Norfolk County Council

Open Floor Hearing 1: Note of oral submission

East Pye Solar (EN0110014)

Deadline 1 – 6 October 2026

Figure 11.6: Likely and Suitable Routes to the Scheme
 Sites 7, 8 and 9
 Revision A

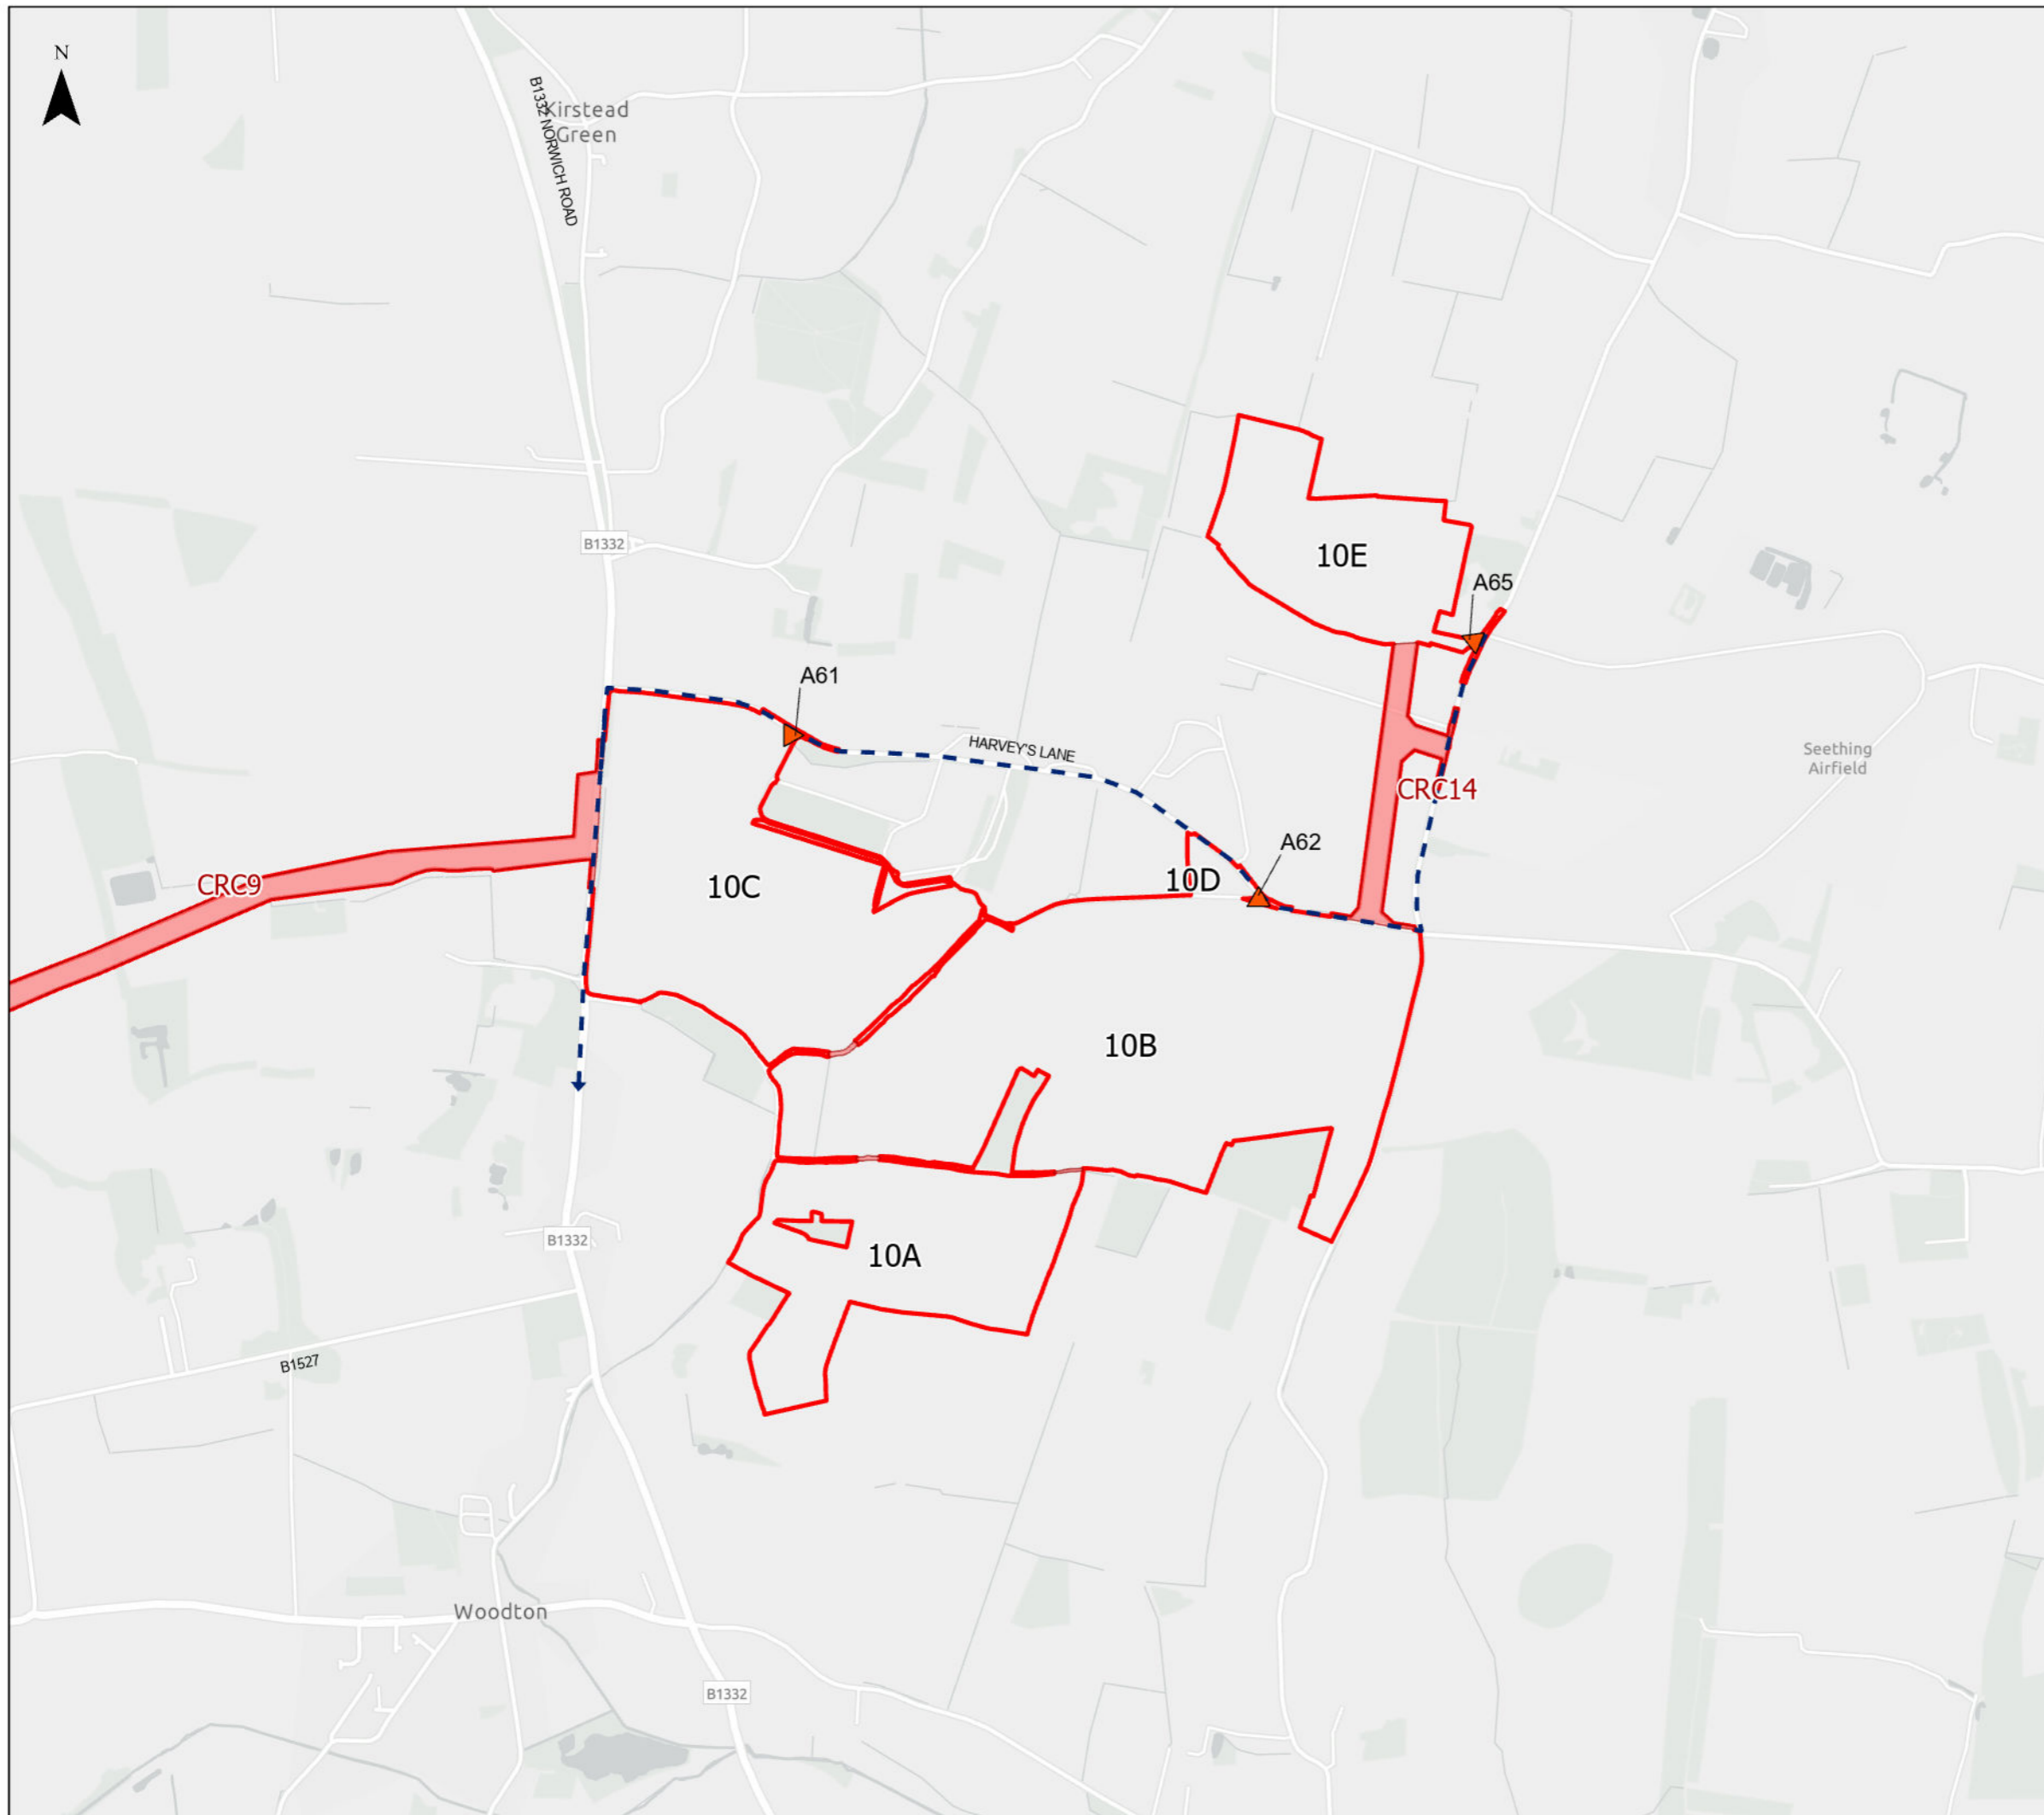
As Highway Authority, we remain unable to support the current construction traffic strategy for Sites 7 to 10 because significant highway constraints and mitigation requirements remain unresolved. Construction traffic must use roads capable of accommodating it safely, and wherever possible should rely on internal haul routes and cable corridors rather than creating avoidable impacts on rural communities.

Traffic and Transport: The preferred construction strategy should rely on internal haul routes from suitably sized roads with appropriate capacity for safe access wherever possible. Traffic should enter from roads capable of safely accommodating construction traffic and movements between sites should occur internally rather than along smaller rural roads and taking access for each site individually. Concerns remain with a number of locations, particularly sites 7-10.

Discussions with the applicant are continuing. Technical Highway officer support from NCC was not available at the hearing and as such no comment was made in response to questions regarding site access via The Krons, Hempnall. Since the hearing, NCC has been able to clarify that the use of the Krons has not been agreed with highway officer, as suggested by the applicant. It was initially considered to be favourable to the initial proposed route via Fairstead Lane. However, in July 2026 NCC informed the applicant that it considered The Krons to be unacceptable as an access route. The preferred access route is using a haul route along CRC8, East of Hempnall, via the B1332.
